Freedom Forever
Planset Revision Letter

7/28/2023
REV #1

AMANDA TURLINGTON
595 MCLAMB ROAD , COATS, NC 27521

ROOF MOUNT PHOTOVOLTAIC SYSTEM

SITE PLAN
 SCALE: 1/64" = 1'-0"

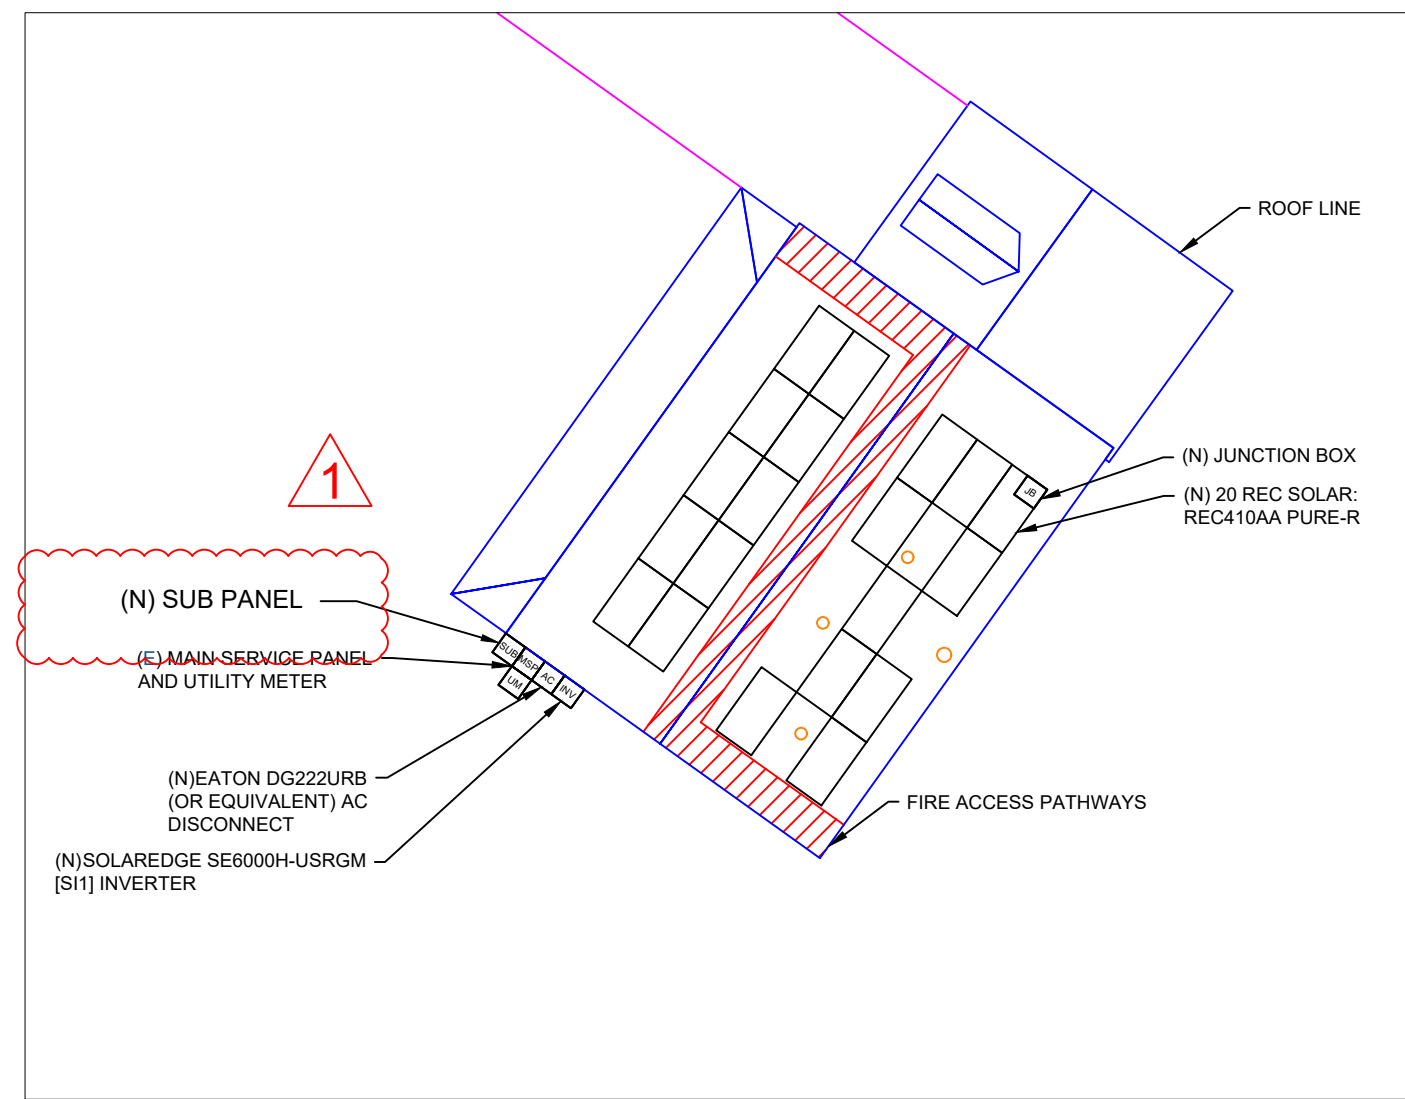
Sub panel added to site plan and ELD corrected
